From: annabel stretton-watts [REDACTED]
Sent: 27 September 2018 23:07
To: Planning
Subject: Ref: BE/89/18/HH – Mr S Rahman, 40 Norbren Avenue

Ref: BE/89/18/HH – Mr S Rahman, 40 Norbren Avenue, Bognor Regis, West Sussex.

1008-02

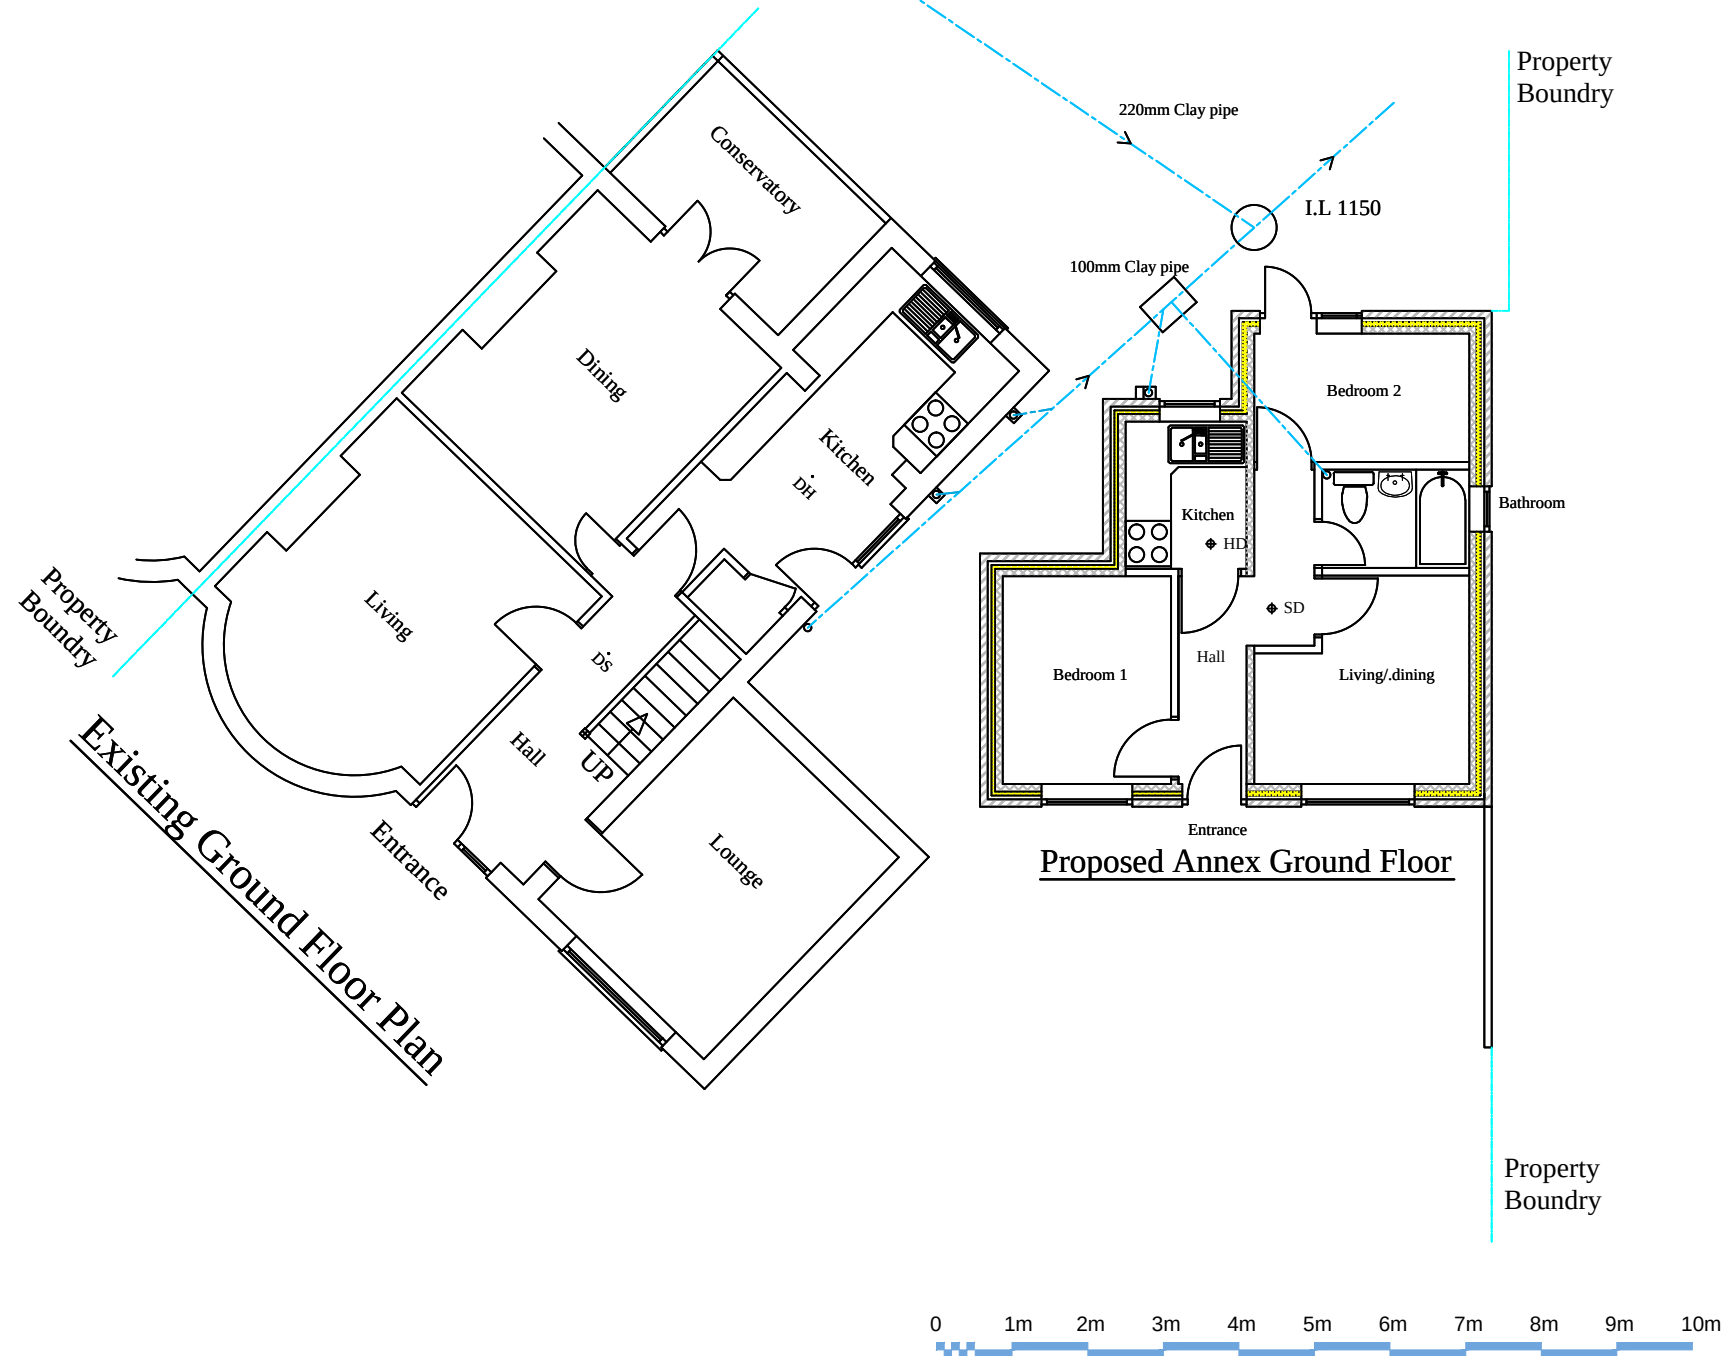
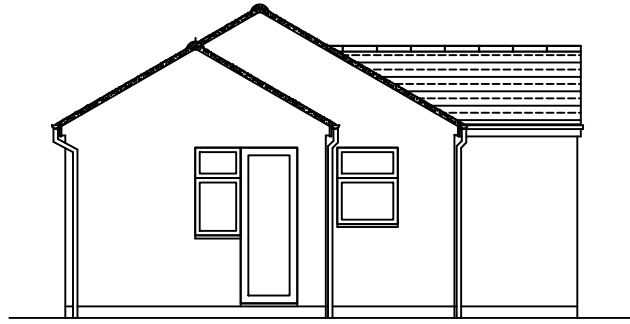
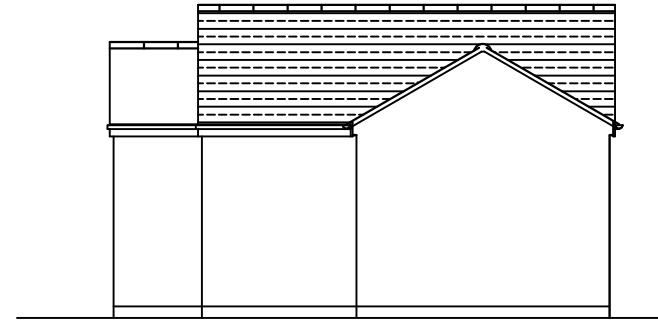
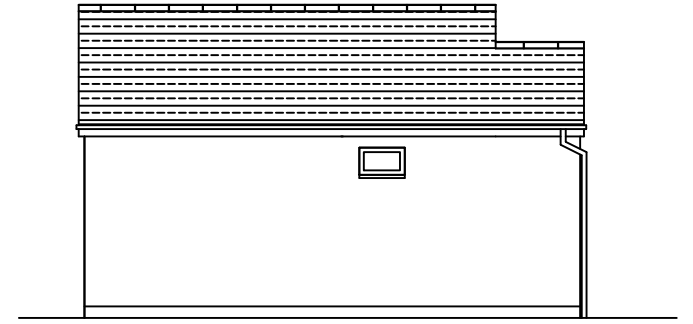
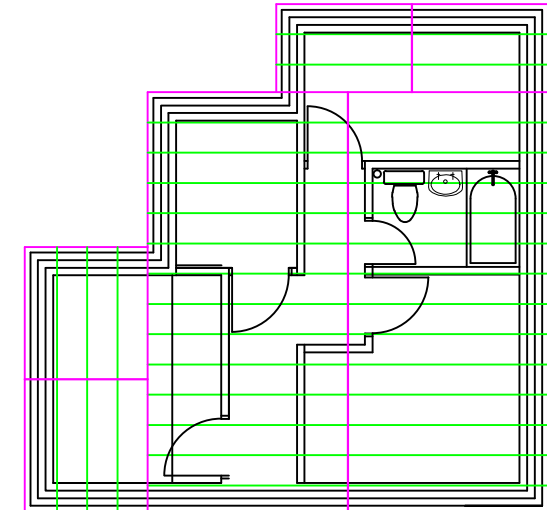
We are objecting to the proposed building of the said 'annexe' at 40 Norbren Avenue. Looking at the plans it can be clearly seen that this is a separate dwelling – a 2 bedroom bungalow which is clearly not attached to the existing property as suggested in the term 'annexe'.
